DRAINAGE REPORT
SOLBERG PLANT
PEYTON, COLORADO

PCD File PPR2432

File No. 0208588-000
September 2024

**C-200**  
Sheet: 5 of 6

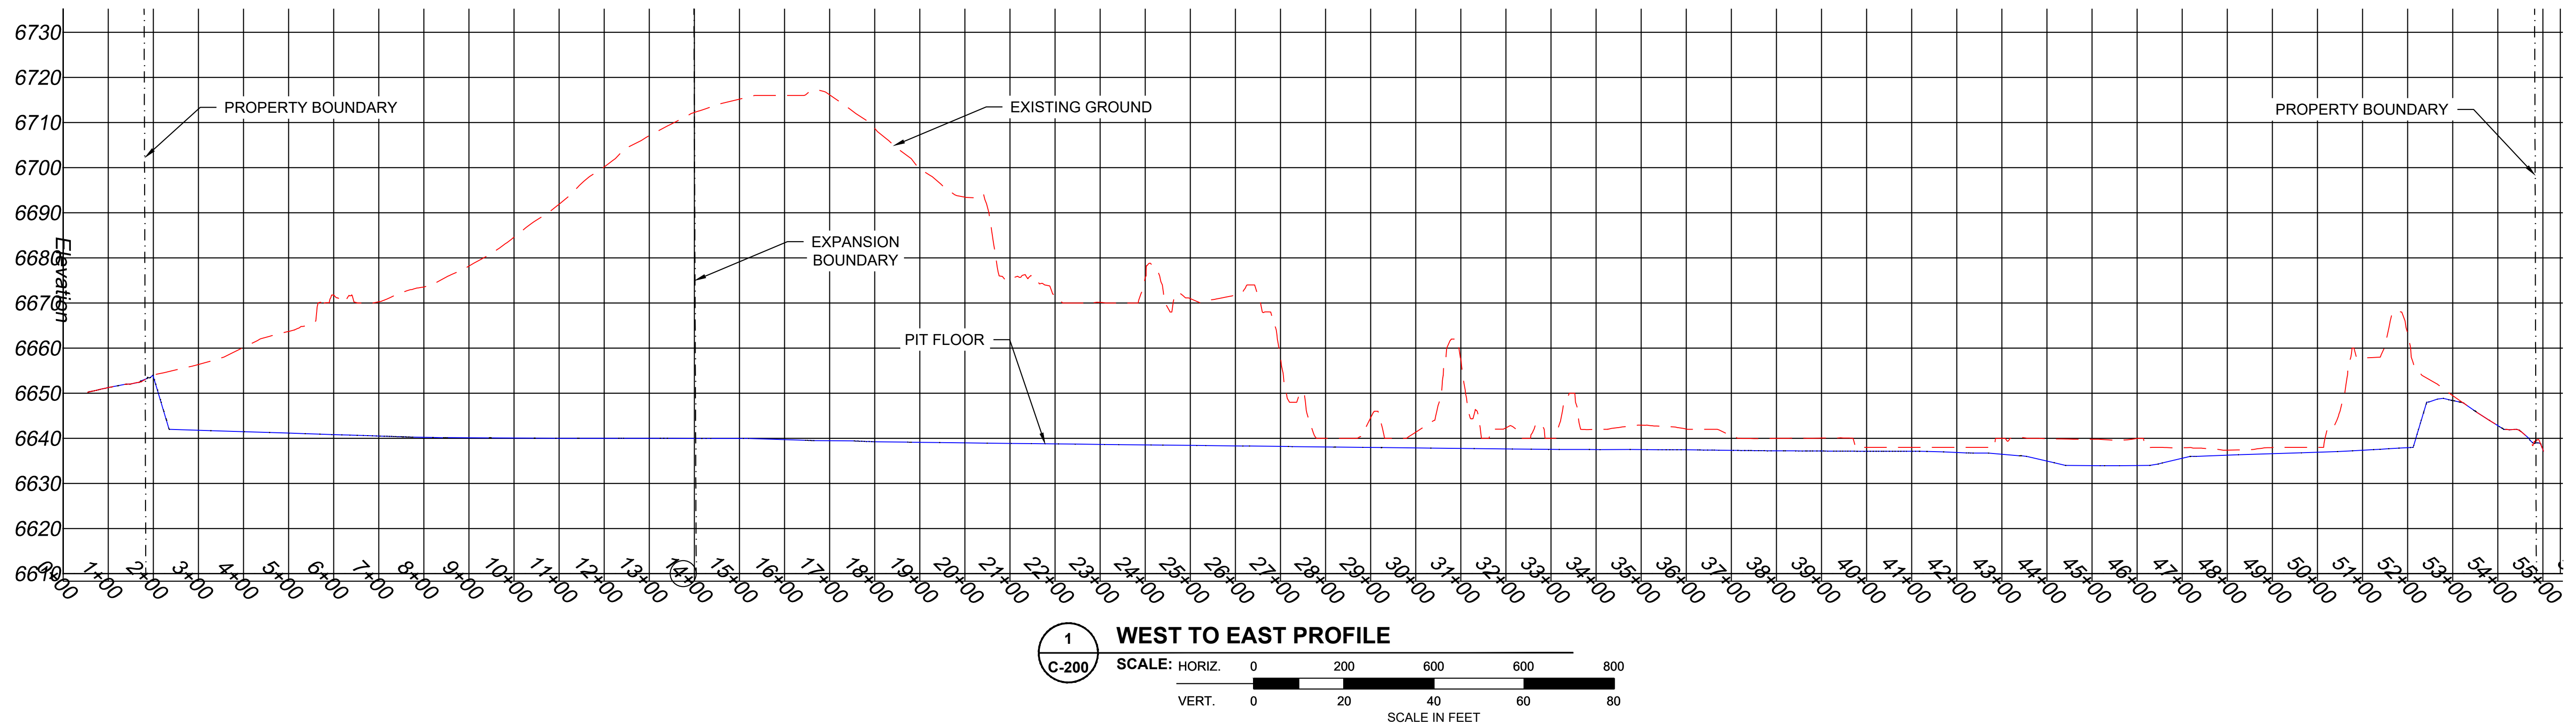
Show the site basins on the drainage maps

Please provide existing and proposed drainage maps with basins shown, flows and Design Point, storm-water infrastructure etc. These maps are different/separate from the Grading & Erosion sheets.
